Stephen O'Donoghue - RE: Noise and blast queries

From: Phil Towler <ptowler@emgamm.com>
To: Stephen O'Donoghue <Stephen.O'Donoghue@planning.nsw.gov.au>
Date: Wednesday, 4 September 2013 12:43
Subject: RE: Noise and blast queries
CC: Oliver Muller <omuller@emgamm.com>, Trish McDonald <Trish.McDonald@cobbo...>
Attachments: MIA.JPG; P0037_LandOwnership_20130830_01.pdf

Operational Noise for Maximum Impact  
Meteorological Conditions - Year 20  
Cobora Coal Project - Environmental Assessment

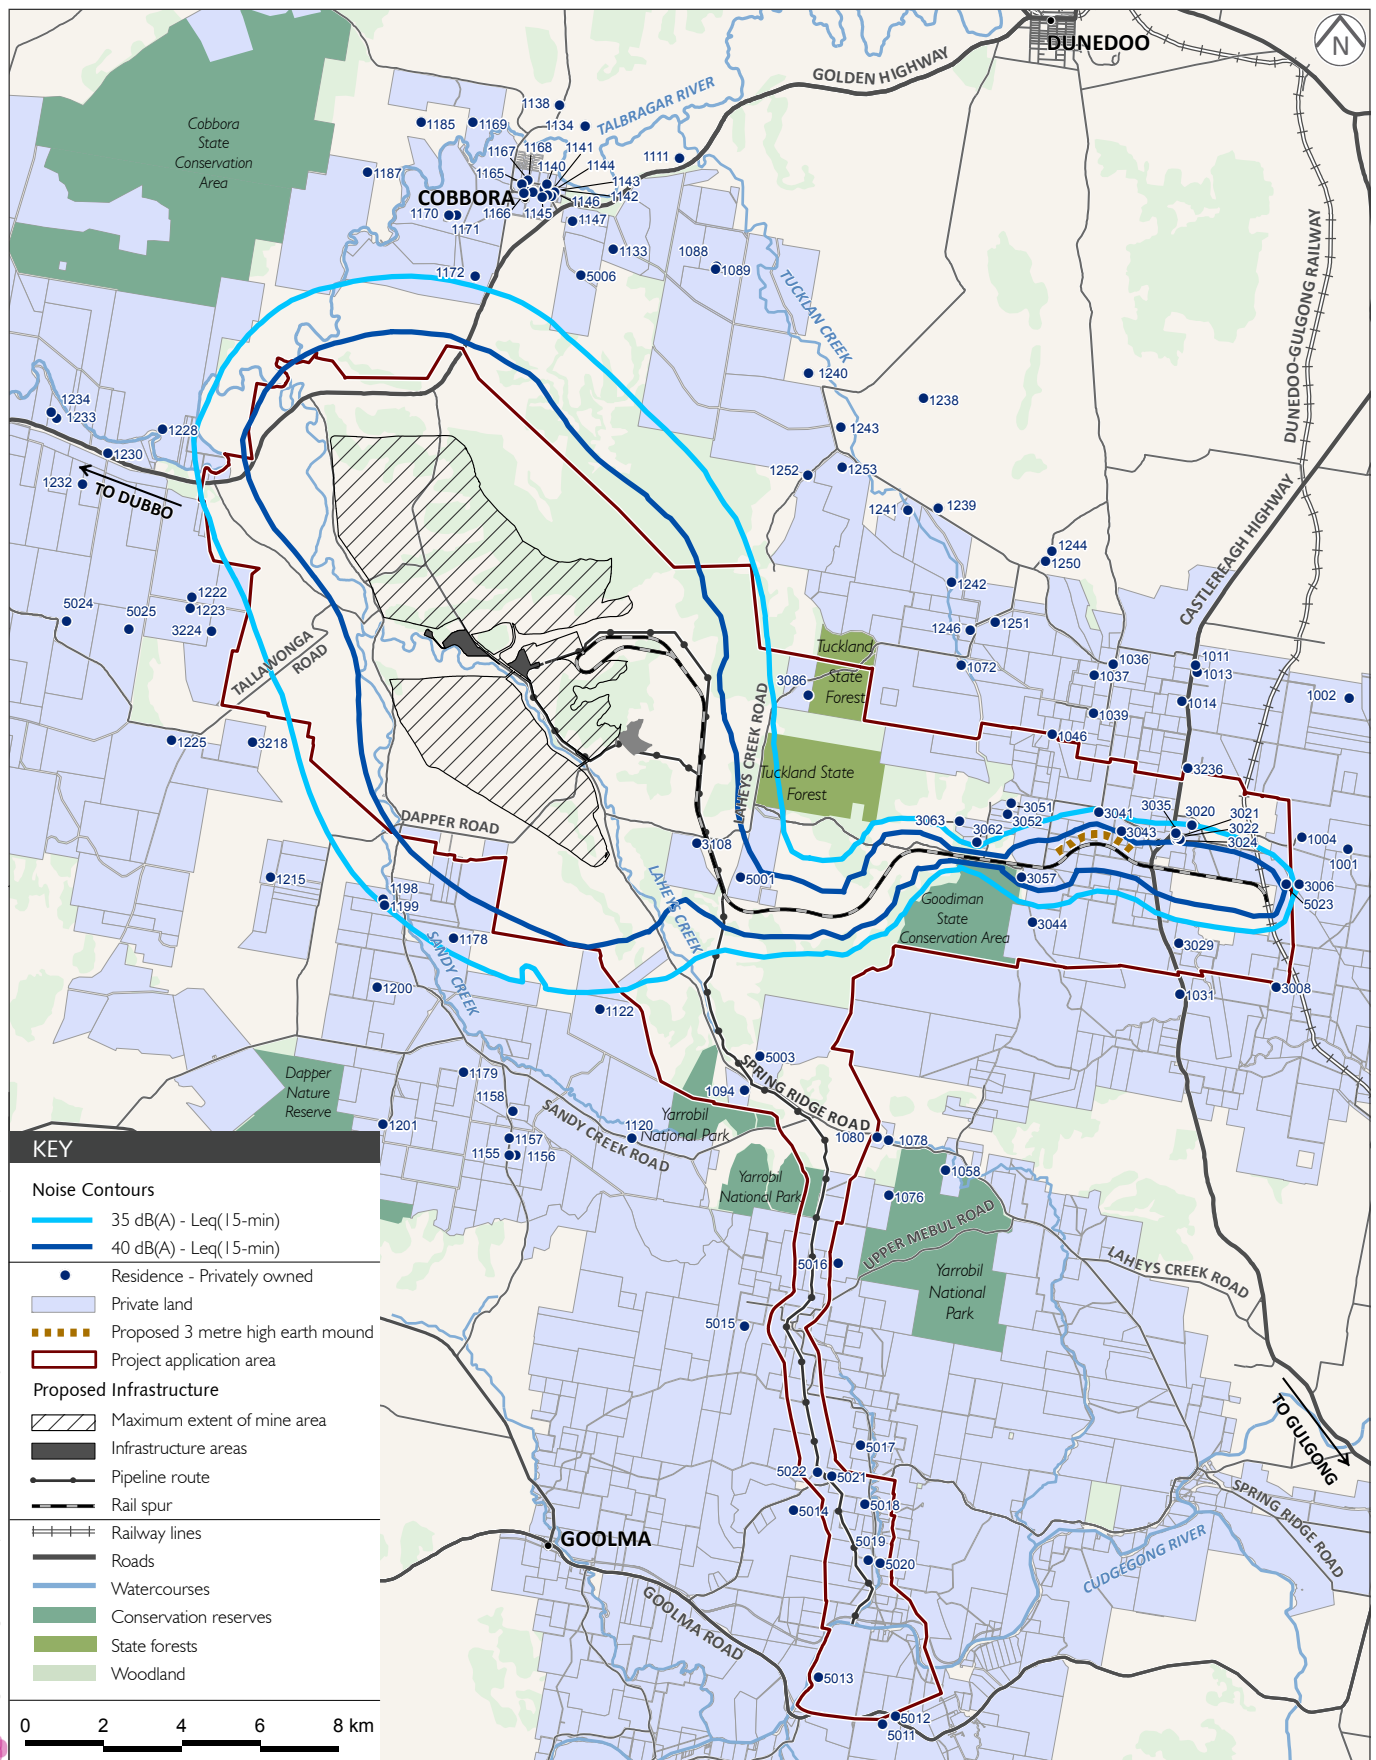
Phil - I just need some clarification on issue of 25% land affected by noise. From Figure 4 from Revised PPR Noise Appendix the 40dBA line extends well into a property as indicated in extract below. From Figure A1 from EA Land owner ship within PA area (see extract below), can you confirm that this land is owned by landowner 33 (Leslie Deutscher), who also owns residence ID 1122. From Appendix A Schedule of Land in EA, 5 lots make up the landholding.

Is this total landholding 2 separate properties owned by the Deutschers?

What is the %landholding affected within 40dB(A) contour across the 2 separate landholding parcels?

The western Deutschers property extends further to the south than shown in the EIS schedule of lands. The lots shown were generally truncated to show only land in or intersecting the PAA. The full extent of the property (33) is shown in the updated schedule of lands map. (We are currently checking the map and will send through a final version and accompanying table shortly).

Based on the worst-case noise scenario (Inversion, Year 20), the 40 dB(A) Leq(15 min) contour covers 22.3% of the western Deutschers property and 13.2% of the total Deutschers land-holdings (see table).

Deutschers property	Area (ha)	Noise Affected	Percent
West	609	135.8	22.3%

East	419	0	0%
Total	1028	135.8	13.2%
